Outer Dowsing Offshore Wind

Response to Section 51 Advice

Schedule of Changes for Plans

Document Reference: 2.0

This document may only be used for the purpose for which it was commissioned and in accordance with the terms of engagement for that commission. Unauthorised use of this document in any form whatsoever is prohibited.

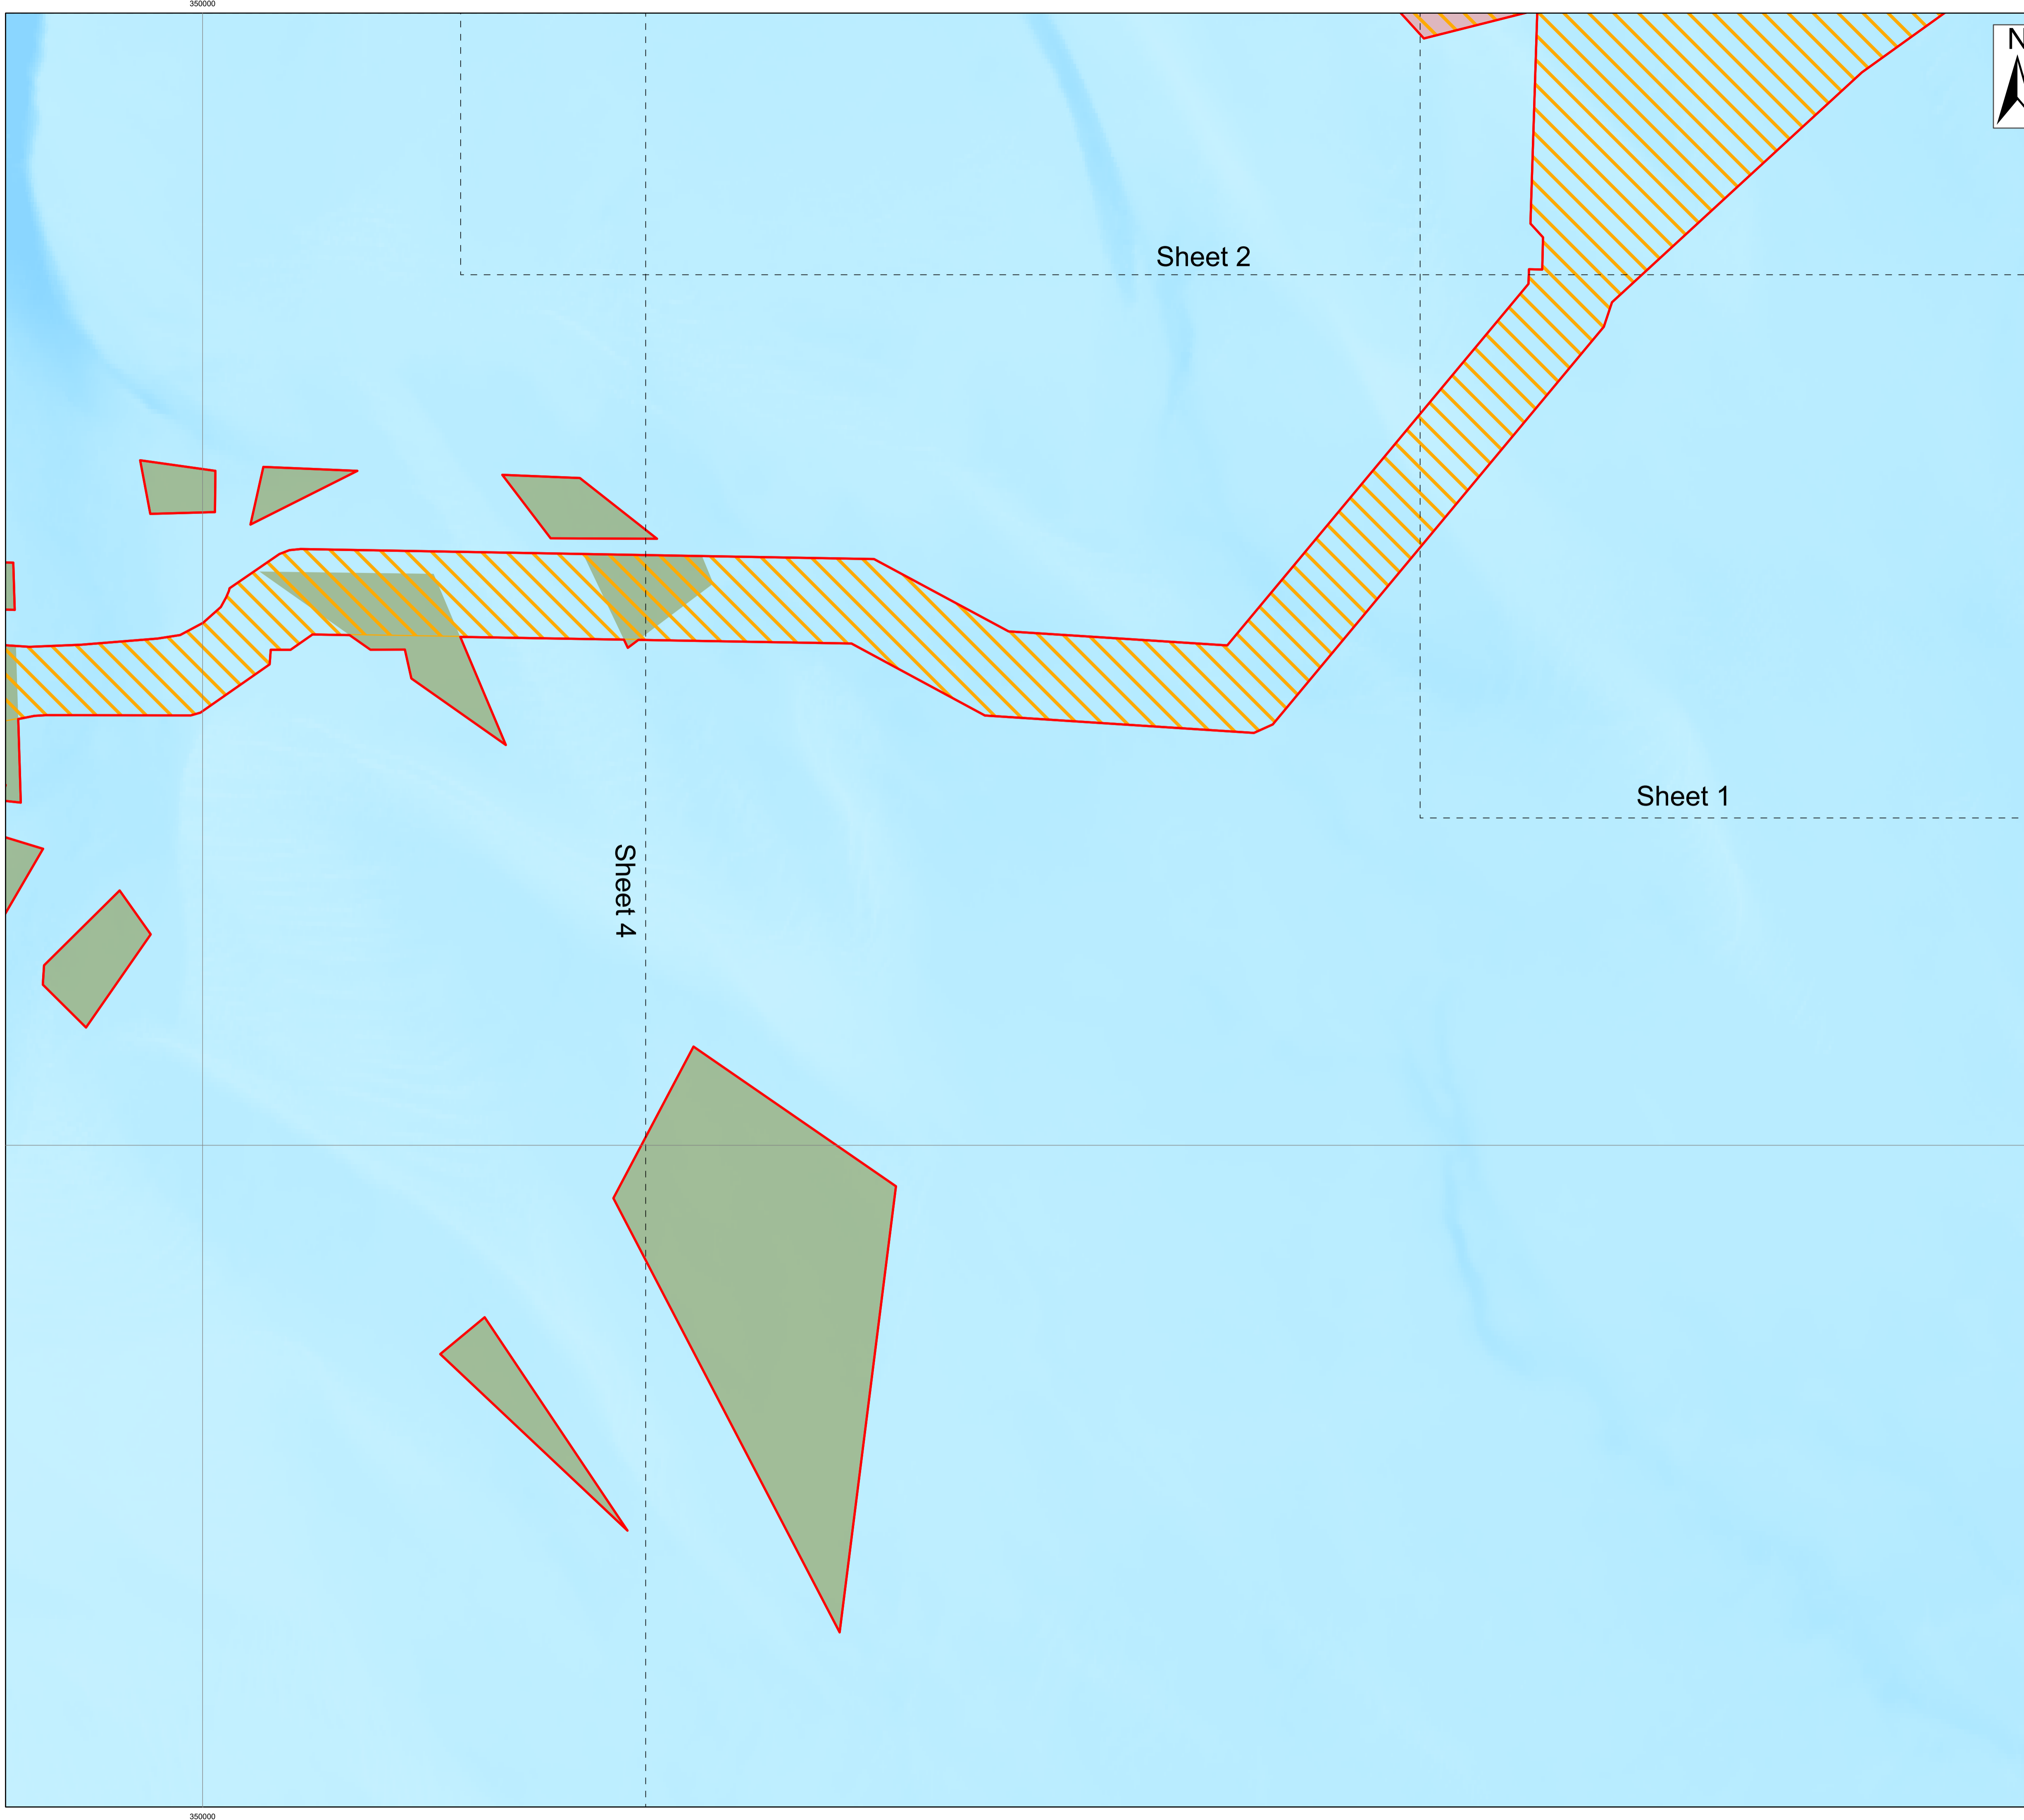
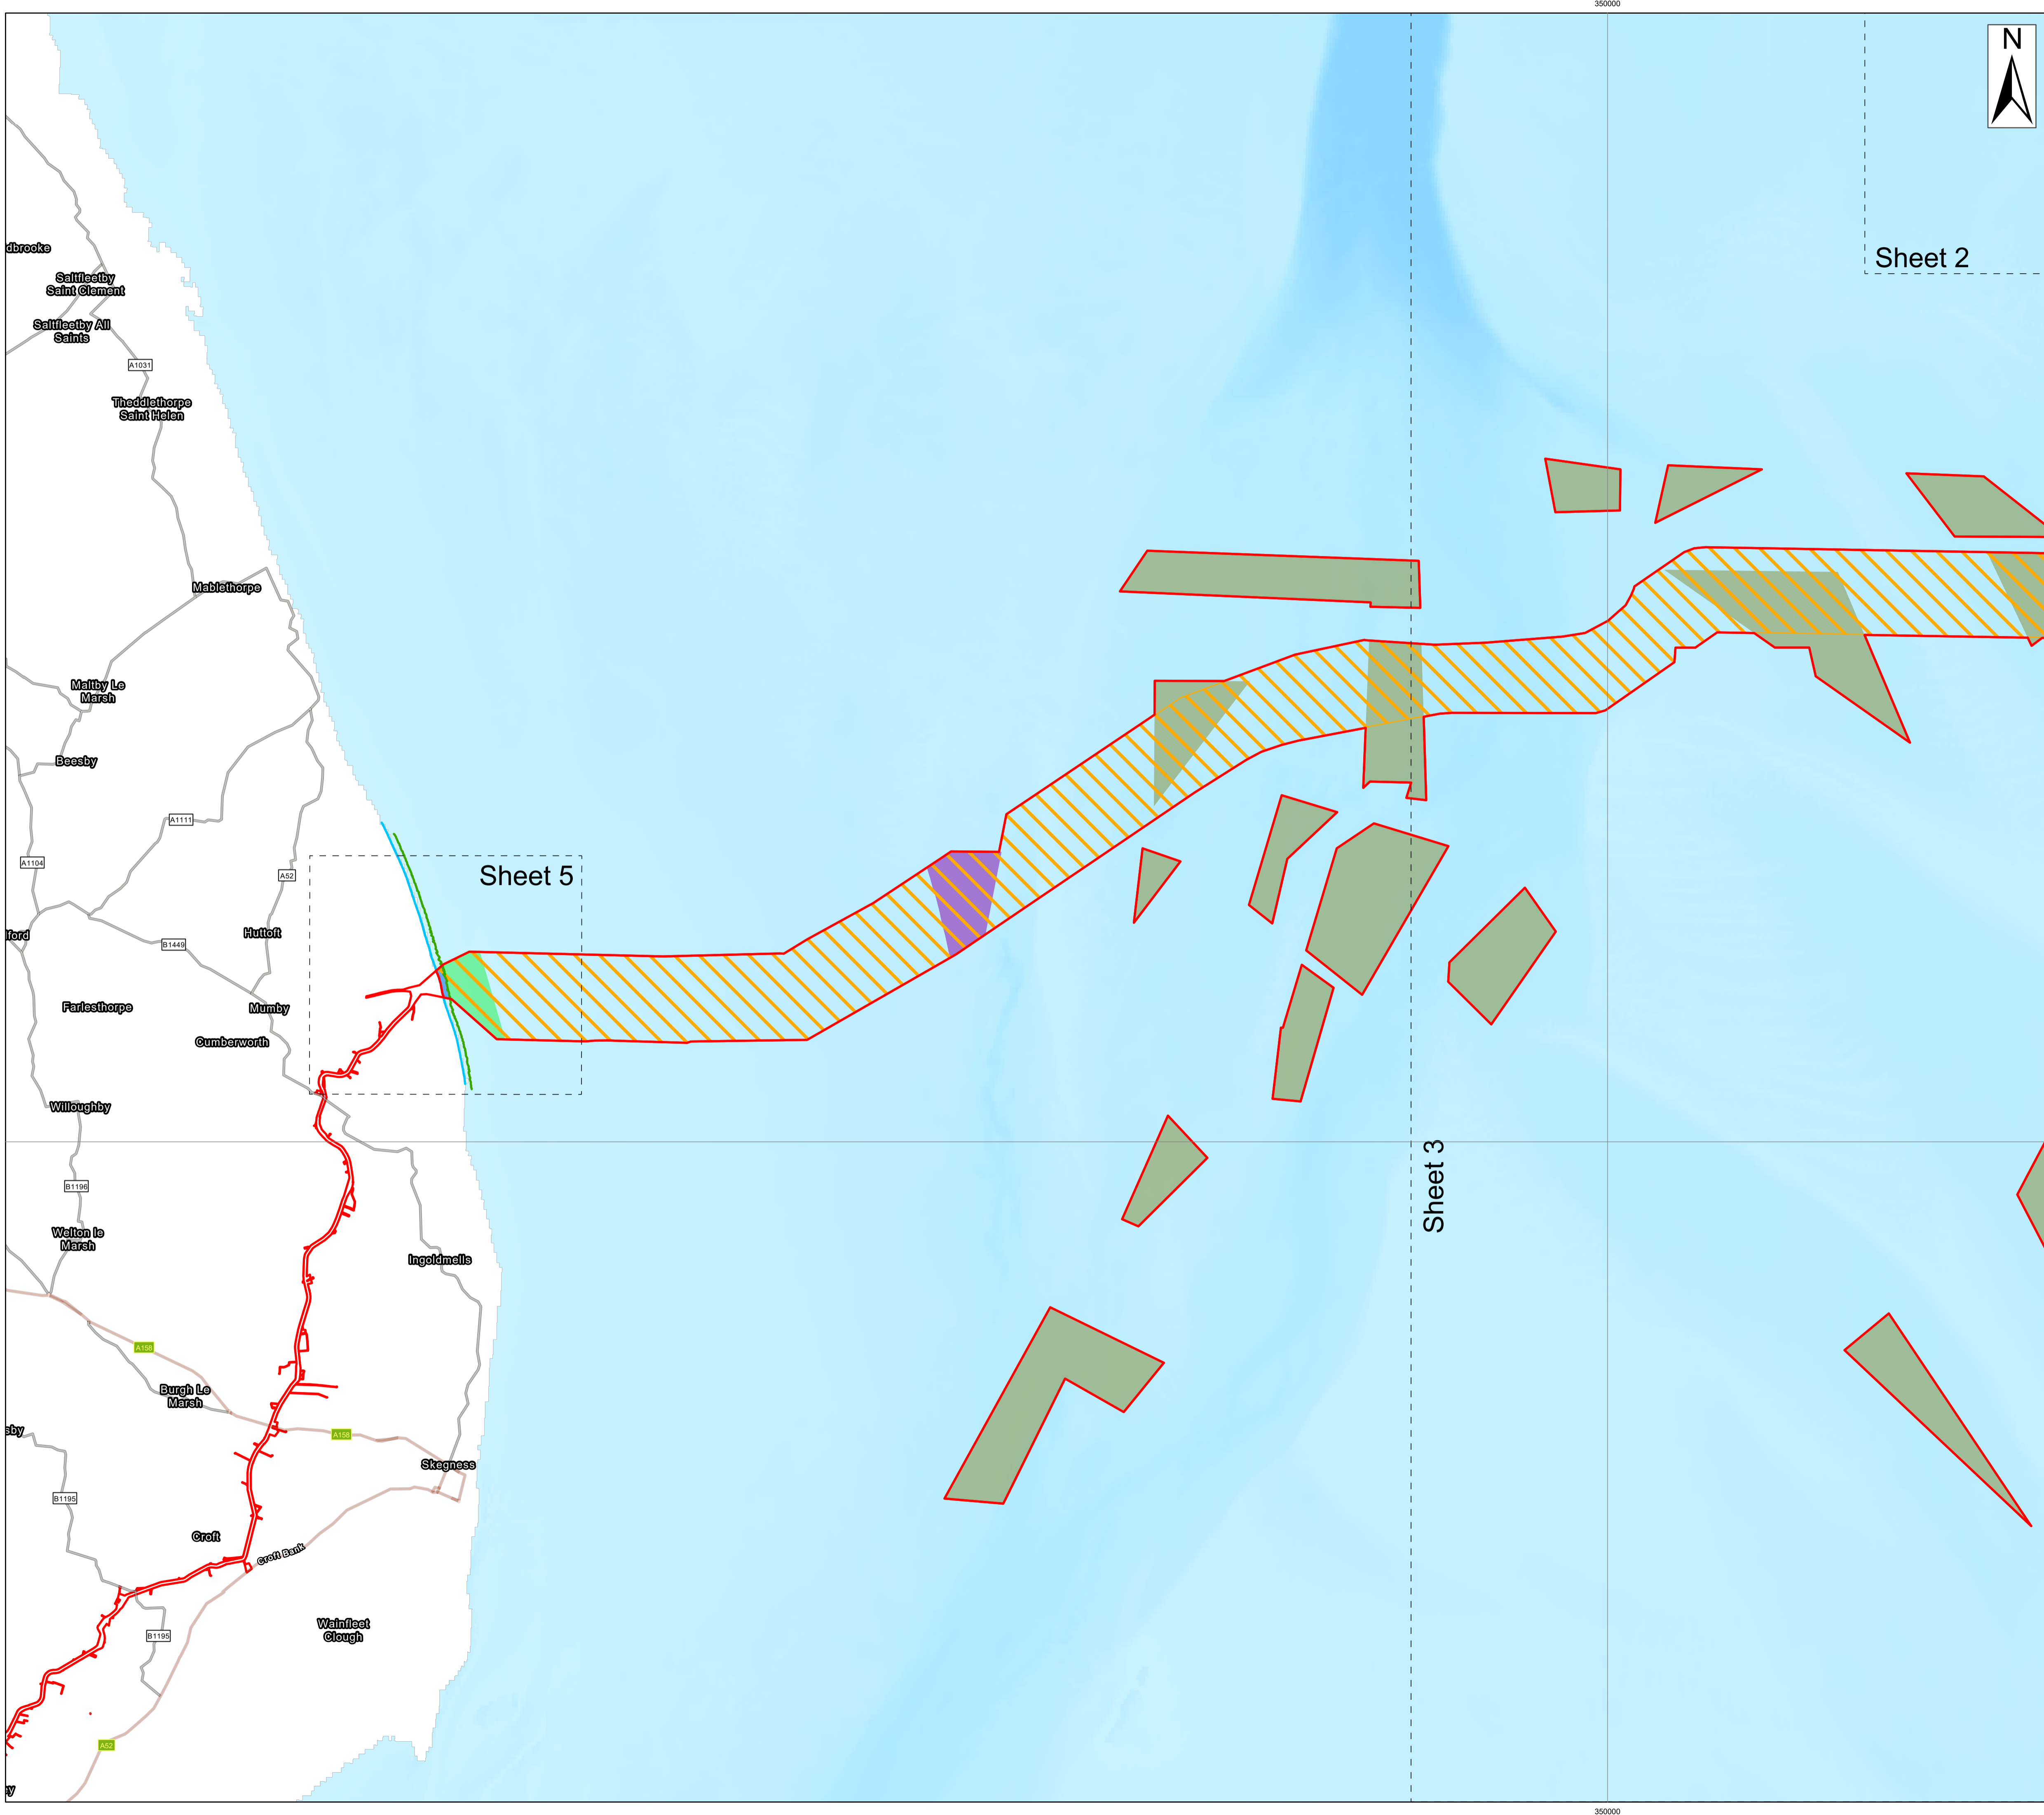
| Plan Numbers | Reference | Plot Number(s) if appropriate | Date of Change | Revision Change | Change Made | Reasons for Change |
|--------------|-----------|-------------------------------|----------------|-----------------|---|--|
| 2.2 | | N/A | July 2024 | V2 | Updated to reflect refined Order Limits | Updated Order Limits due to updated MHWS/MLWS datasets |
| 2.2 | | N/A | July 2024 | V2 | Amended works descriptions to better align with the DCO | Section 51 Advice request to align key text with the draft DCO works descriptions. |
